LU/67/20/PL

The proposal is for two replacement windows and a door to the apartment. The existing windows and door which are the subject of this application do not appear to be original to the building.

Proposed East Elevation of Rear Outrigger - 1/100

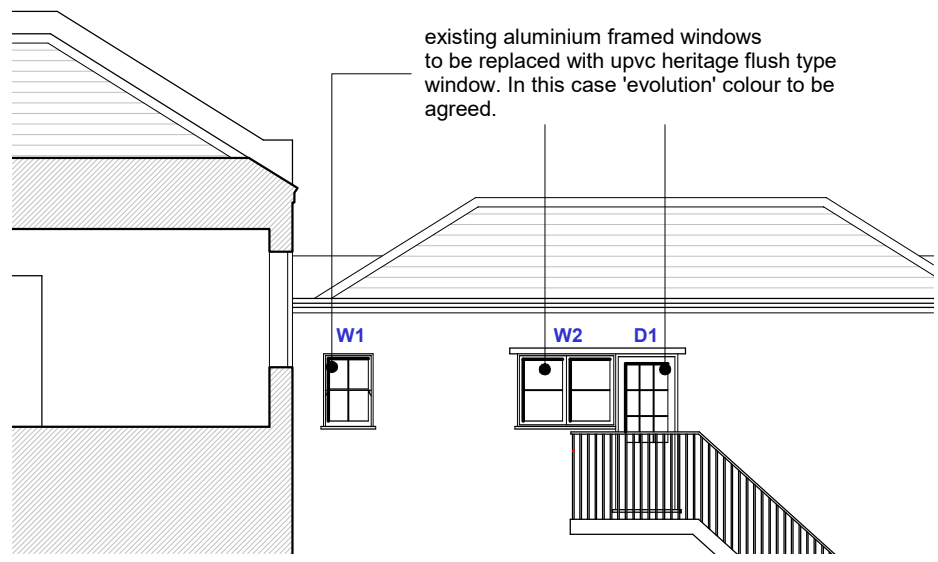
I note that the application seeks permission for the replacement of windows constructed from UPVC. UPVC is not a traditional, vernacular material and is unsuitable for use in historic buildings. The location of the windows does not detract from the impact that they have upon the building. In fact, supporting windows constructed from this material in the proposed location could be seen as support for this type of window more generally.

I should also point out that UPVC windows are also unsustainable; it is tricky to repair them, with often the only viable option being to replace them in their entirety. In addition, they require continuous cleaning to prevent discolouration from dirt and ultra violet light, and regular maintenance.

Such a proposal is considered to cause harm to the listed building. The proposal is such that the impact can be described as causing less than substantial harm in accordance with paragraph 196 of the NPPF (2019). As such, you will also need to consider the public benefits that the development may achieve as part of your assessment of the application, along with the contents of the Planning (Listed Buildings and Conservation Areas) Act 1990 (as amended).
